CITY OF ALBUQUERQUE

September 23, 2016

RE: **Copper Townhomes
Grading & Drainage Plan
Engineer's Stamp Date 8-15-16 (File: K17D111)**

ENGINEER'S SEAL	Title: Copper Ave. Townhouse Condos	DRAWN BY
		GRADING AND DRAINAGE PLAN	DATE
		RSD Engineering, LLC 4305 Purple Sage Ave. NW ALBUQUERQUE, NM 87120 (505) 288-1621	SHEET # X of X
Richard Dourte P.E. #10854			JOB #

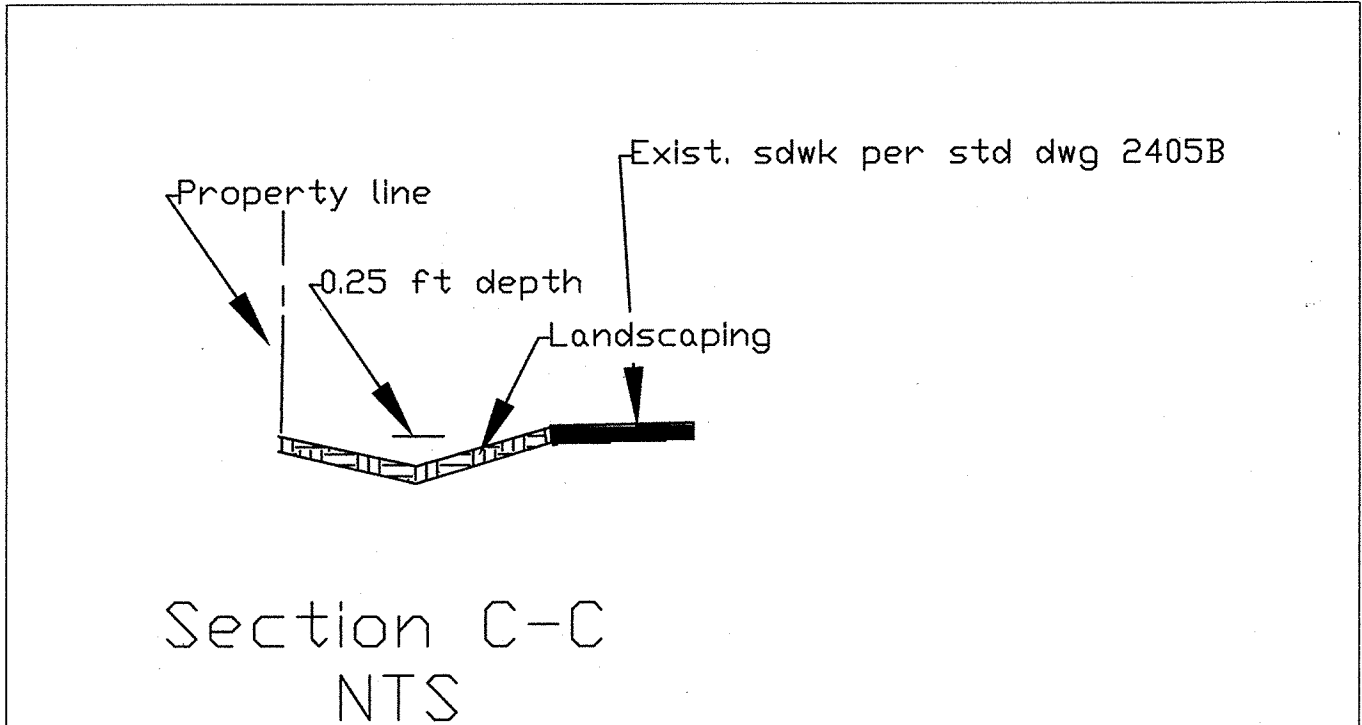
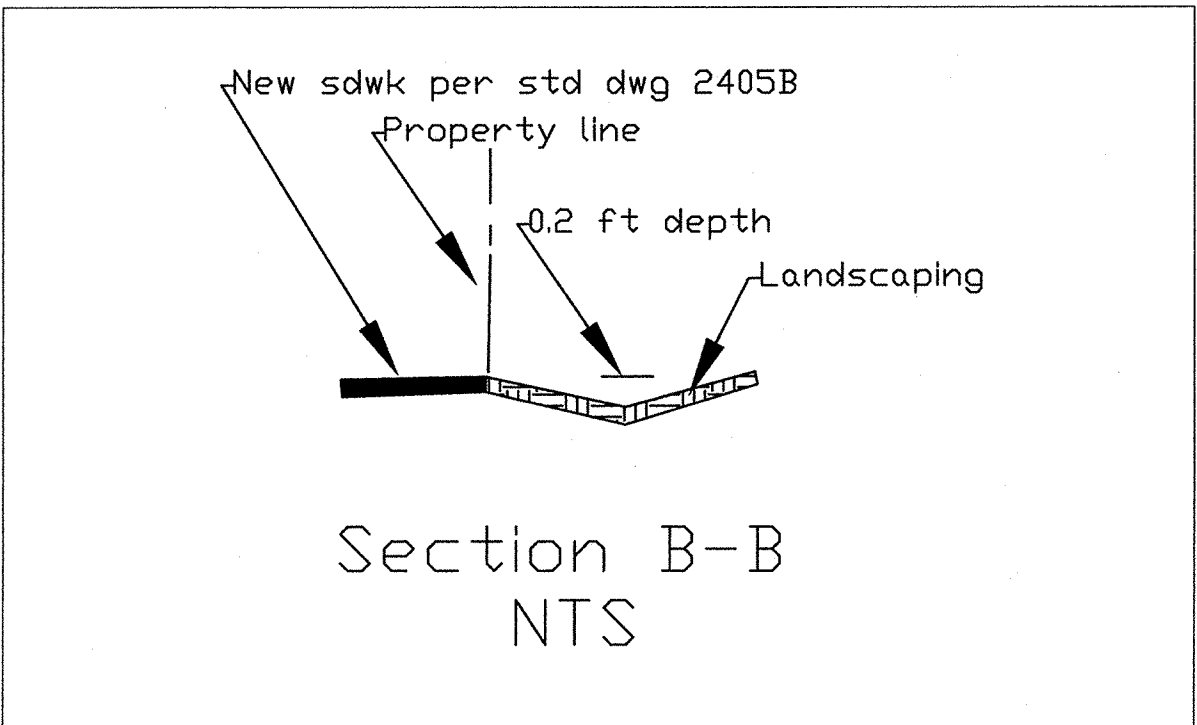
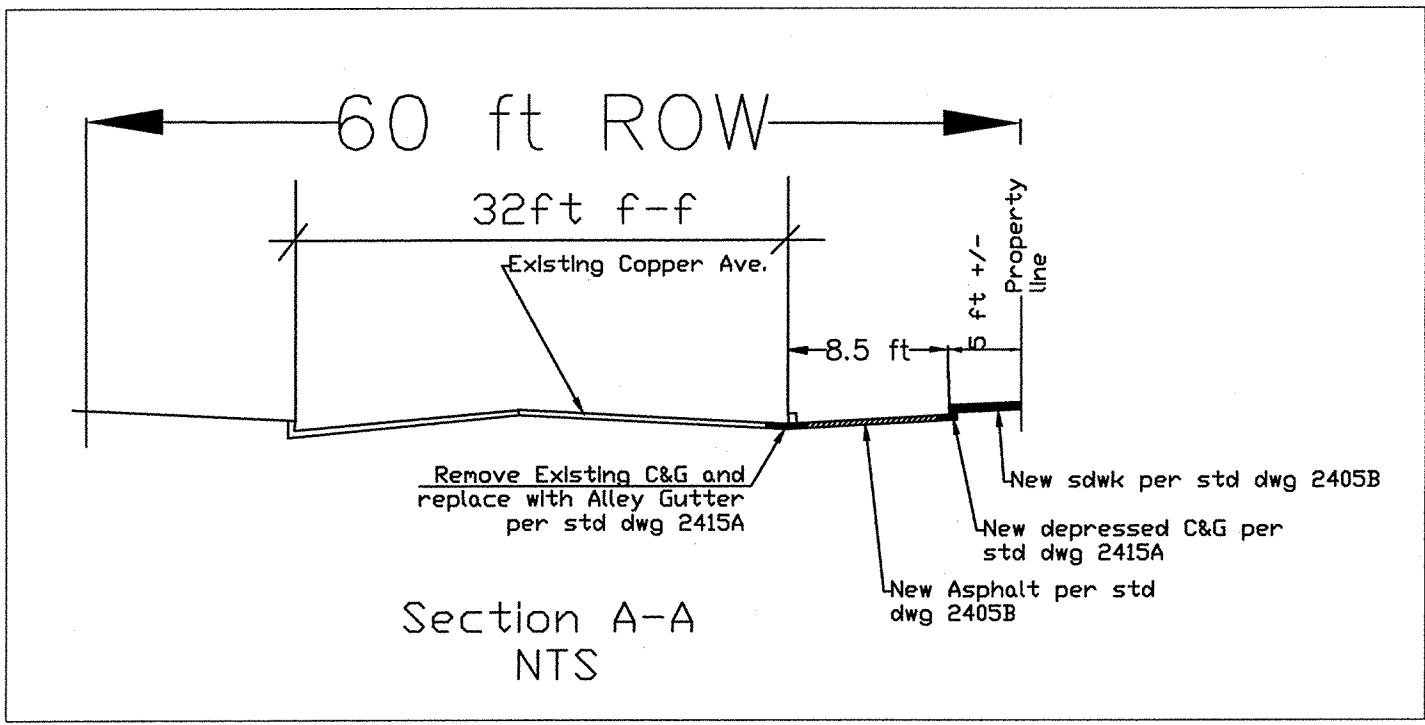
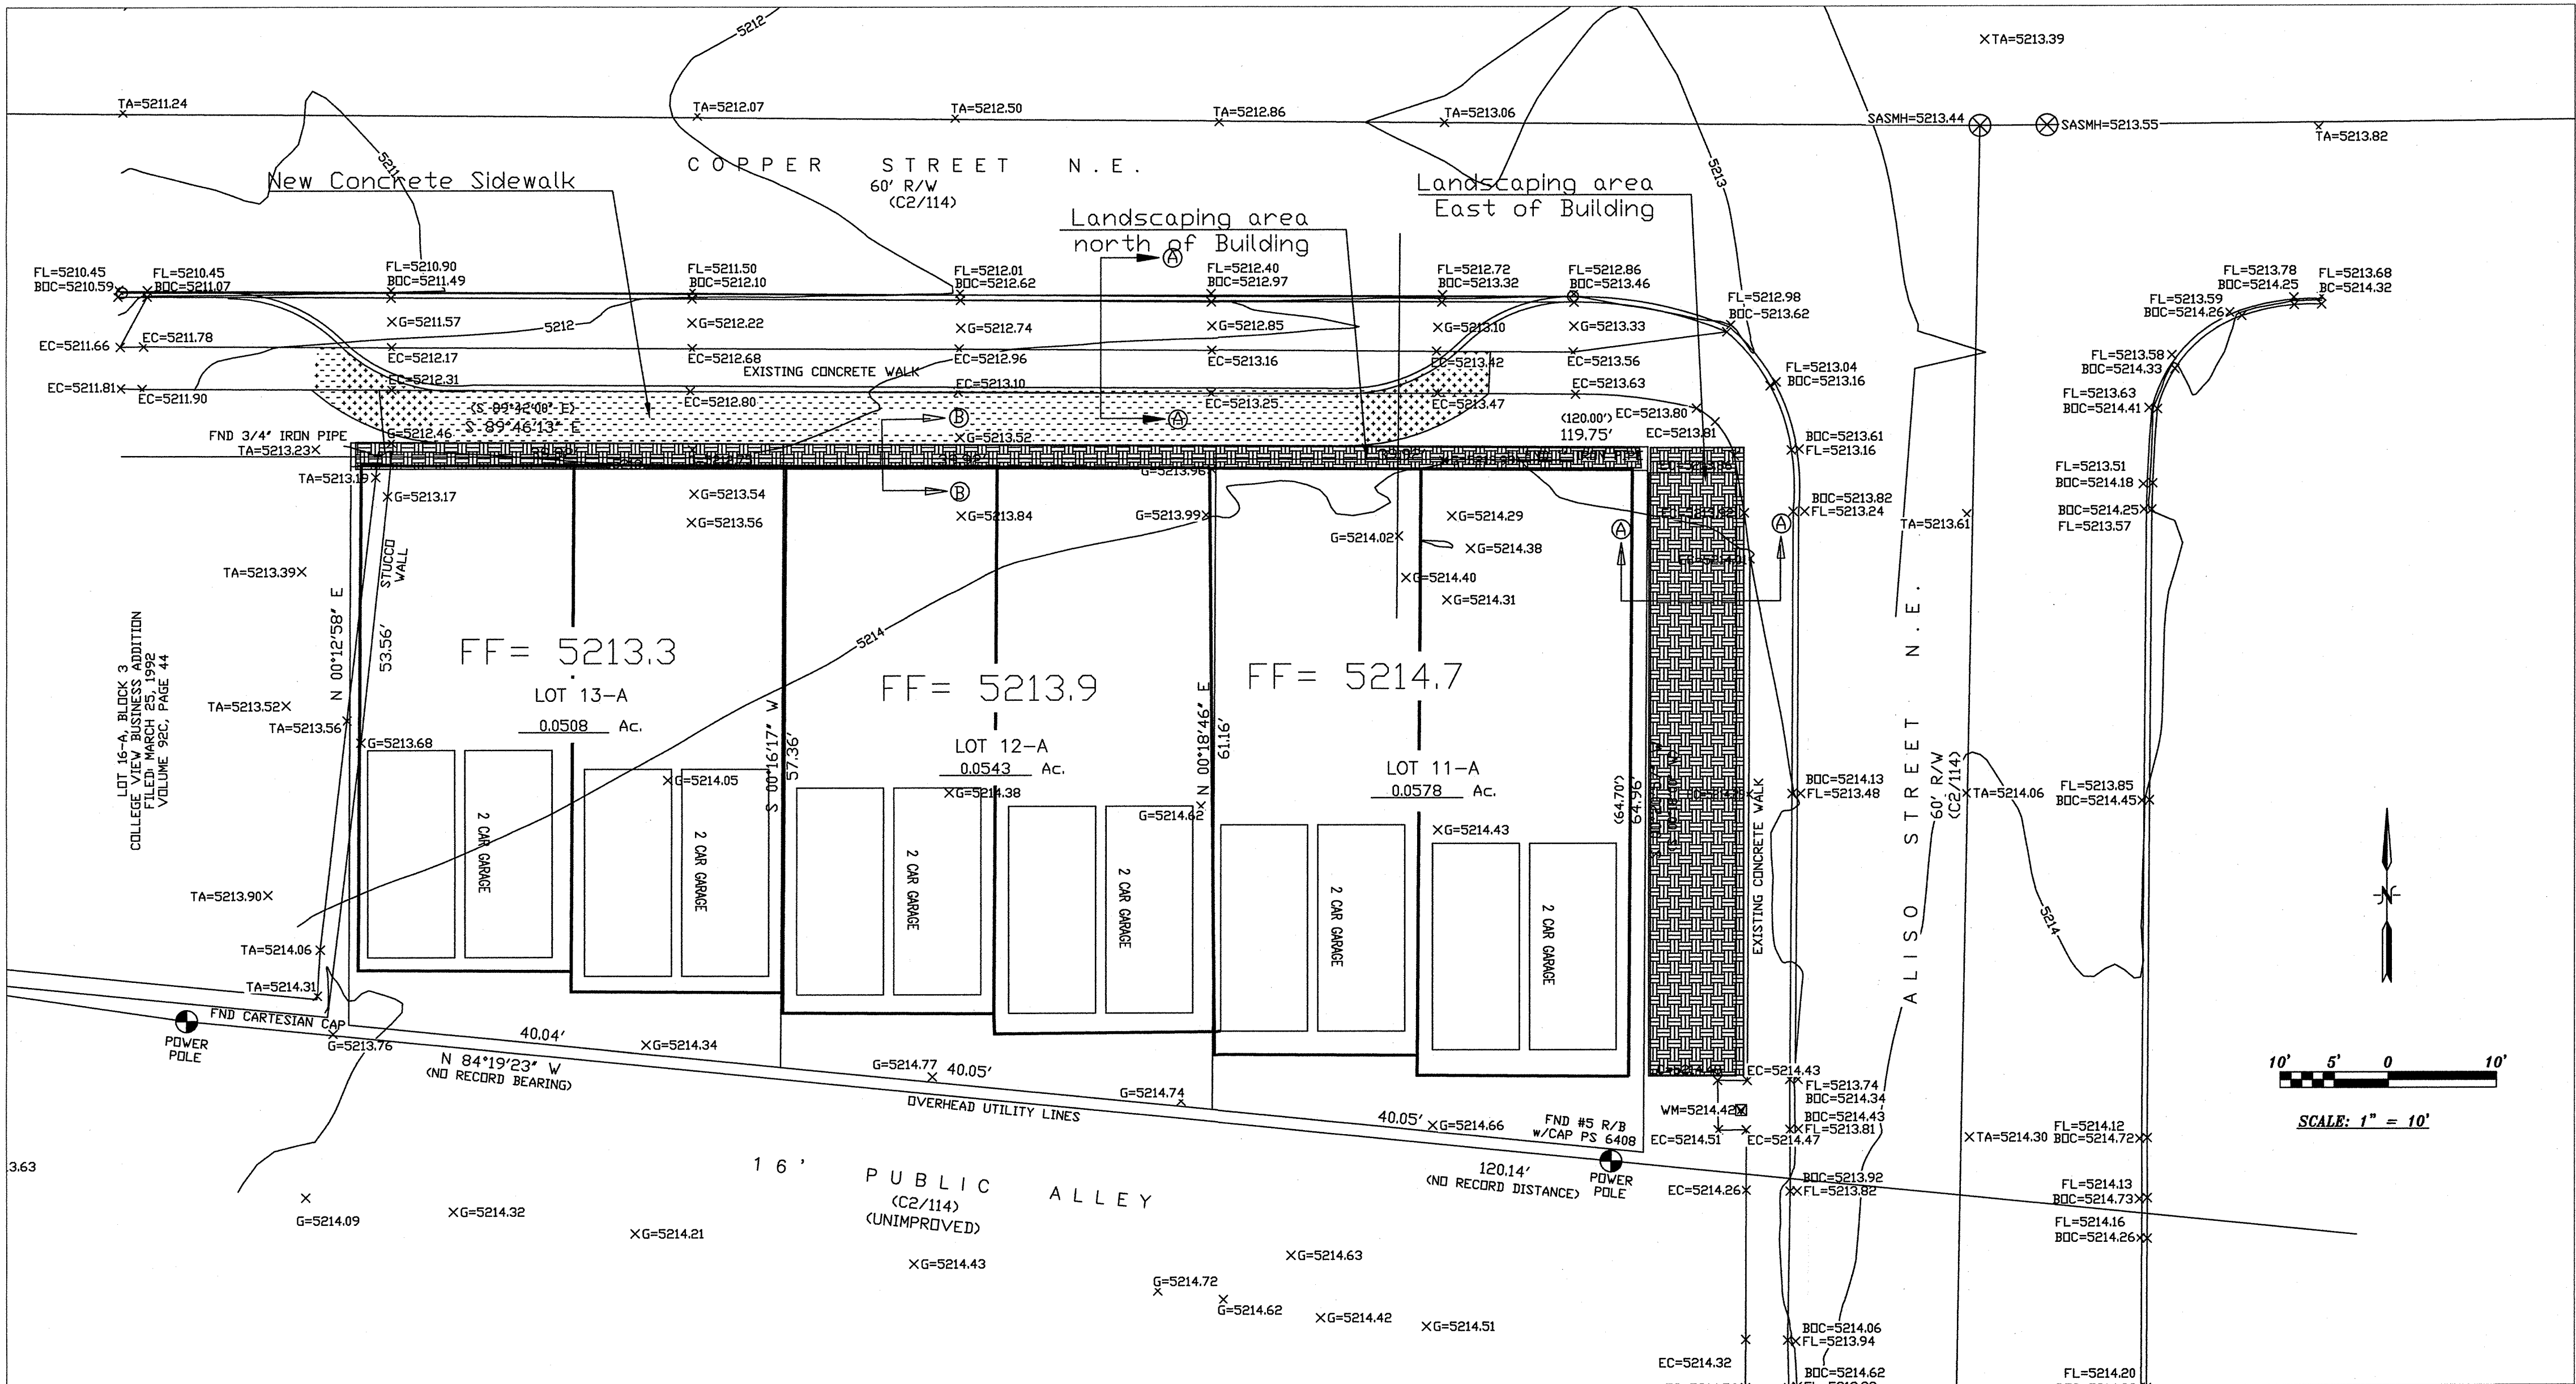
- a. A wall appears to be encroaching into the proposed building on Lot 13-A.
 - b. There are dimensions shown that are floating on the plan without leader lines (39.92', 120.14', 40.05', etc).

- c. The building landing notes show a single elevation and it's not clear where it is to be set. Furthermore, consider incorporating a minimum slope to prevent nuisance ponding/ice patching near the building entrance, (the single elevation suggests that it is to be laid flat).

- d. The landscape buffers appear to be shown flat graded along the north face of the buildings; are they intended to drain? The sidewalk culverts have no build notes or dimensions, and they are offset from the apparent roof drain locations.

- e. Disconnected and broken line work implies that the electronic drawing might have issues that the Contractor will need assistance with in the field (if the contractor uses the electronic file for staking).
